**EL PASO COUNTY PLANNING AND  
 COMMUNITY DEVELOPMENT  
 DEPARTMENT**

**GRADING AND EROSION CONTROL PLAN CHECKLIST**

SF2138

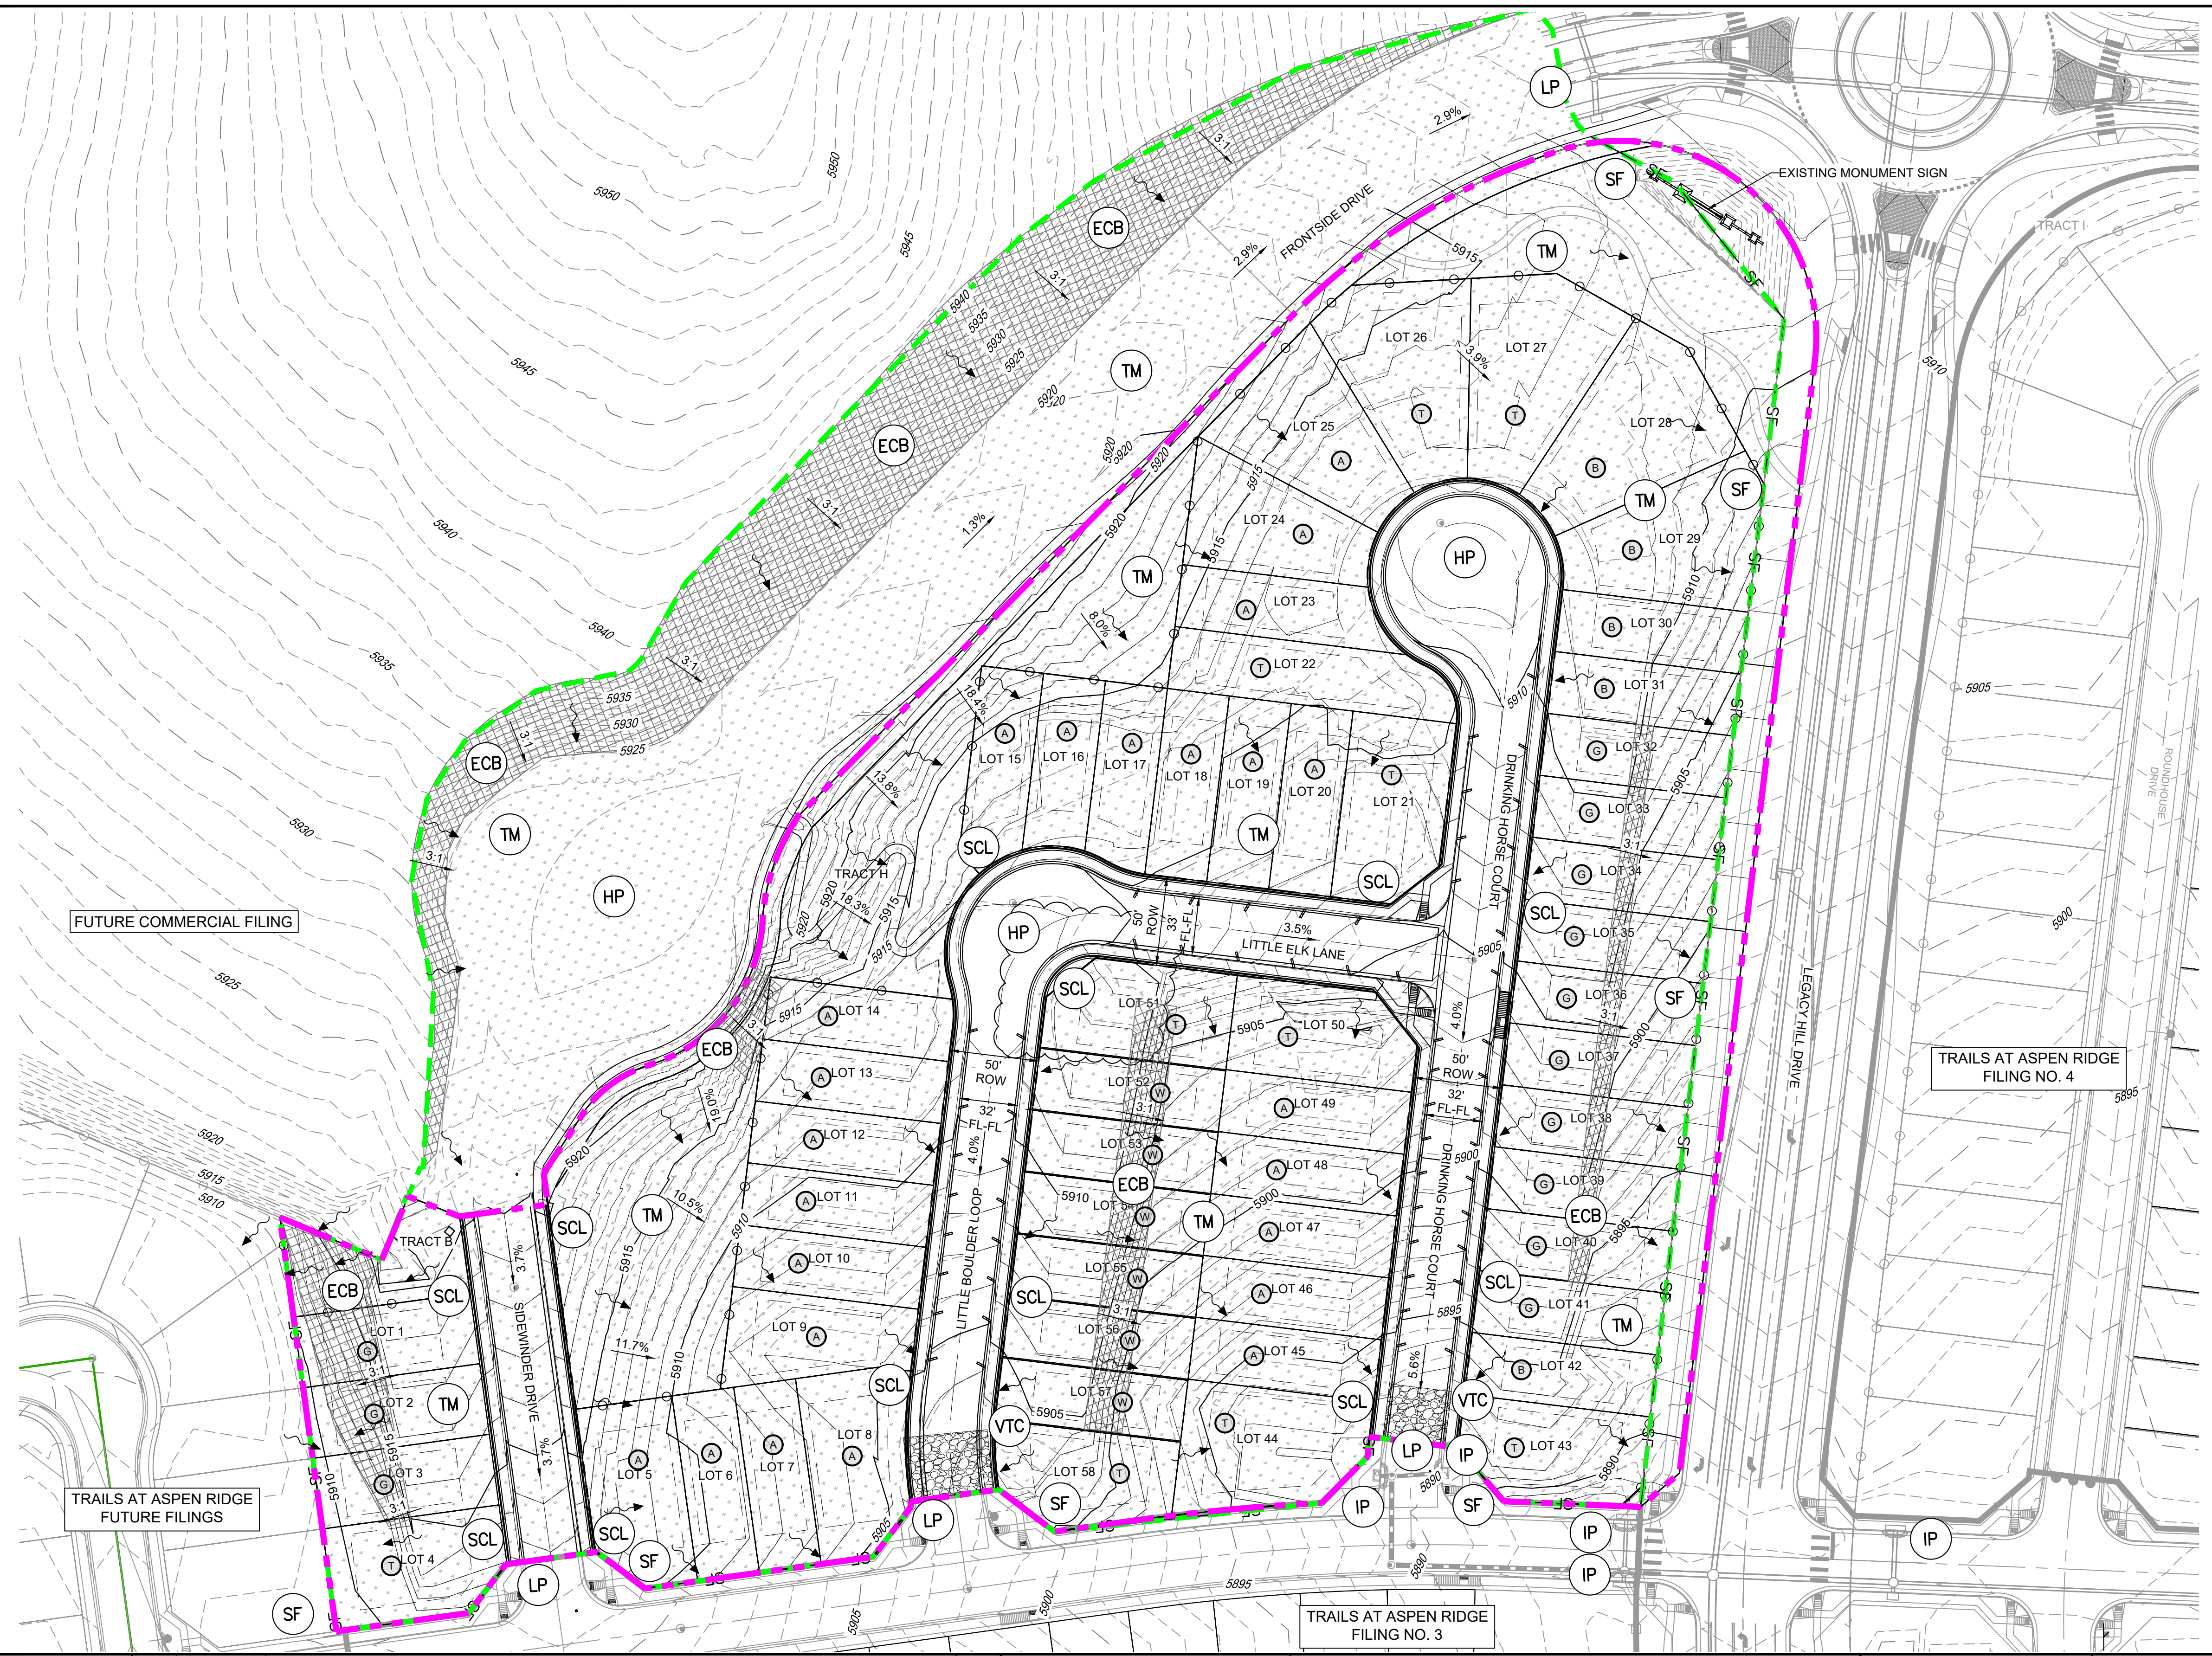
|  |   | Applicant | PCD |
|--|---|-----------|-----|
| p  | Areas of cut and fill identified.   | Y         | N   |

after addressing the need or lack thereof in drainage report, this may not require any additional action on the GEC Plan and I can mark as "Y"

Cut and Fill not added because the existing surface has been overlotted graded already. Existing and proposed are similar and a cut fill line is not able to be created
